St Anthony of Padua Catholic School Redevelopment (SSD-8865)
Request for Additional Information

I refer to Response to Submissions (RtS) for the St Anthony of Padua Catholic School Redevelopment (SSD-8865). After careful consideration, the Department is requesting that you submit additional information that effectively addresses the issues identified in **Attachment 1**.

DRAWING
DETAILED PROPOSAL
SITE PLAN EXISTING -
AERIAL PHOTO

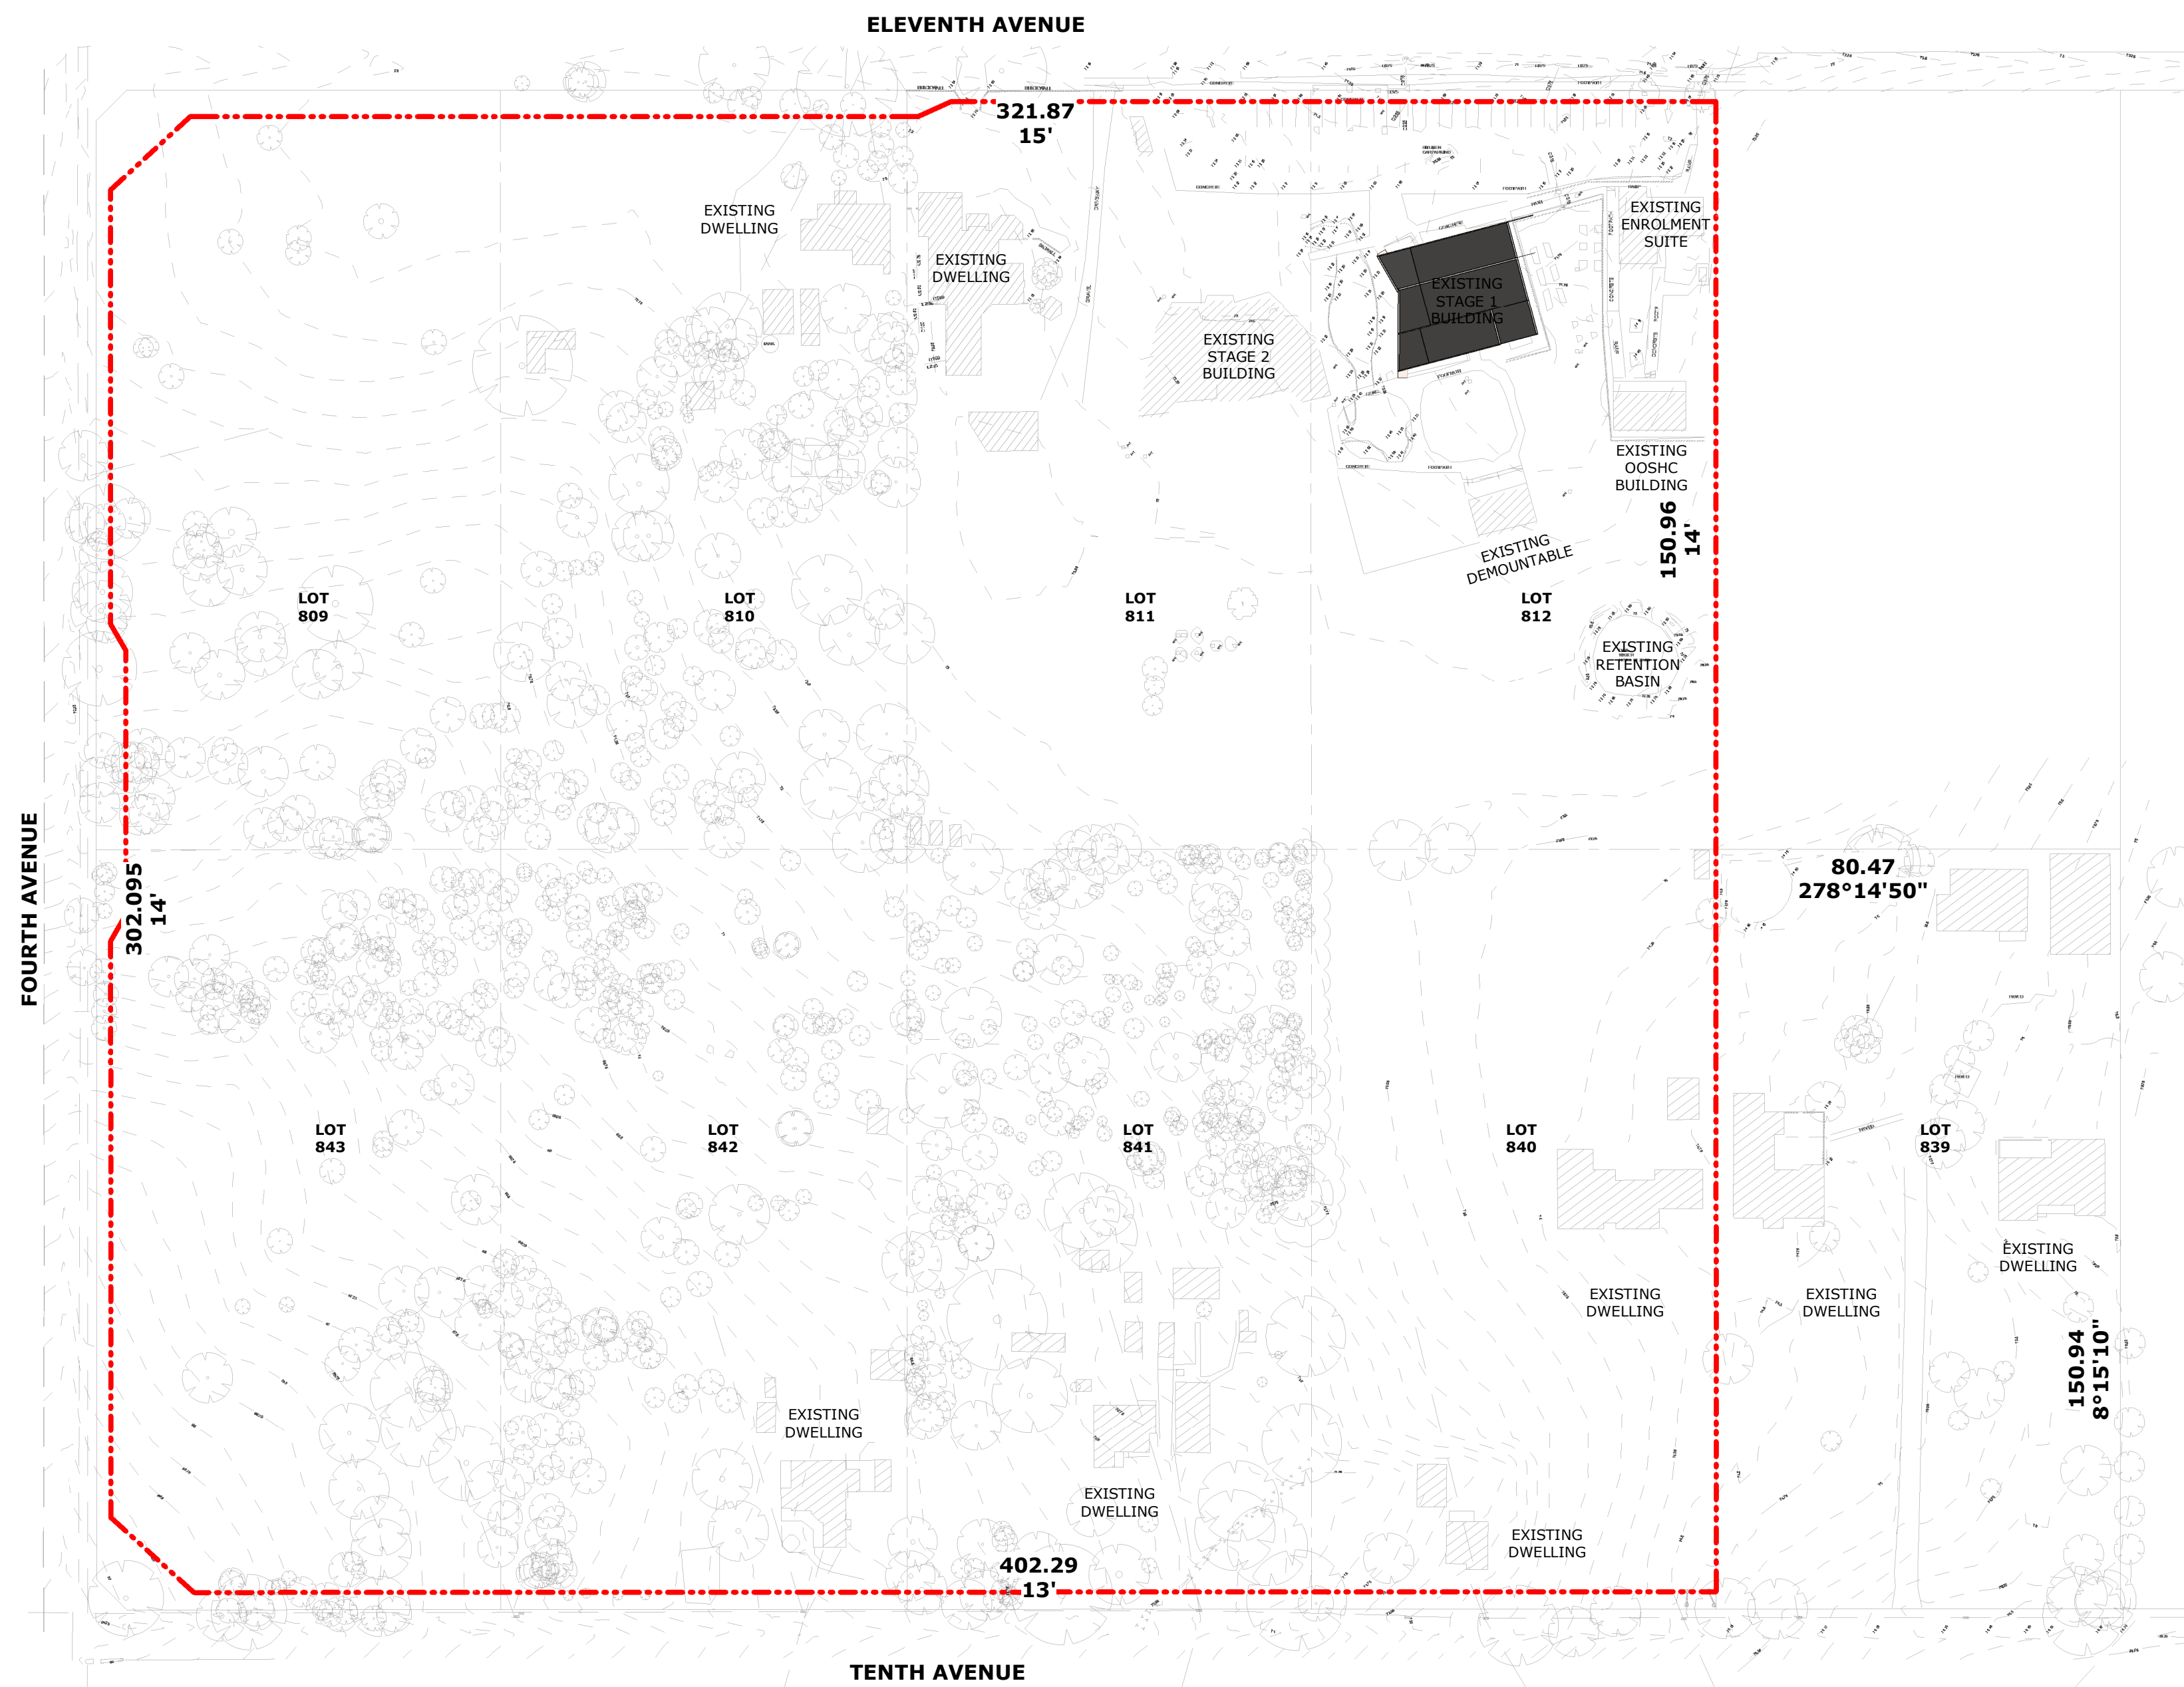
- a landscape plan detailing the interim landscaping at the locations for the future church and trade centre areas should be provided.
- the 'Site Plan – Detailed Proposal' (DA005) should be updated to identify both the existing and proposed boundaries, consistent with all other plans. The Site plan must demonstrate that all structures, including the roof of the Indoor Recreation Centre and any perimeter fencing (including fencing on Tenth Avenue) are to be located wholly within the new boundaries of the site.
